PRE-HEARING STAFF ANALYSIS

Rezoning Petition No. 2008 - 090

Request: B-1(CD), neighborhood business, conditional district and O-2(CD), office, conditional to B-2(CD), general business, conditional district and O-2(CD)S.P.A., office, conditional district site plan amendment

SECTION A-A SCALE: 1/16"=1'-0"

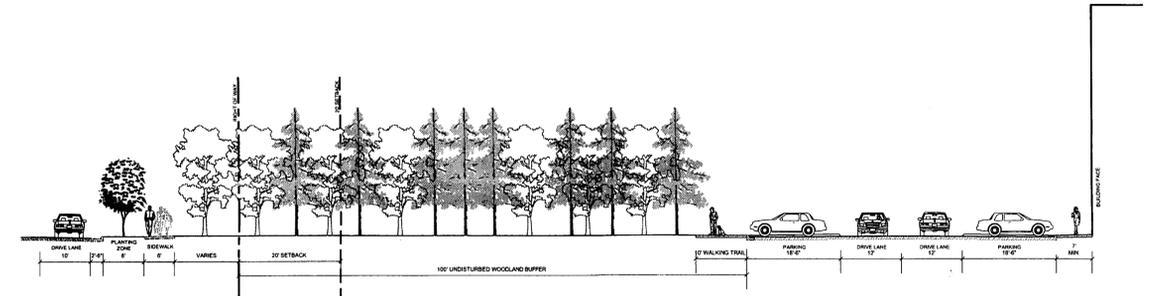
- The petitioner should revise road cross sections A-A and B-B on sheet L3 to include a 5-foot sidewalk on both sides of the road.
- The petitioner should revise the building elevations on sheet L5 to indicate building materials, and add articulation to break up the blank walls, on the building elevation looking north.
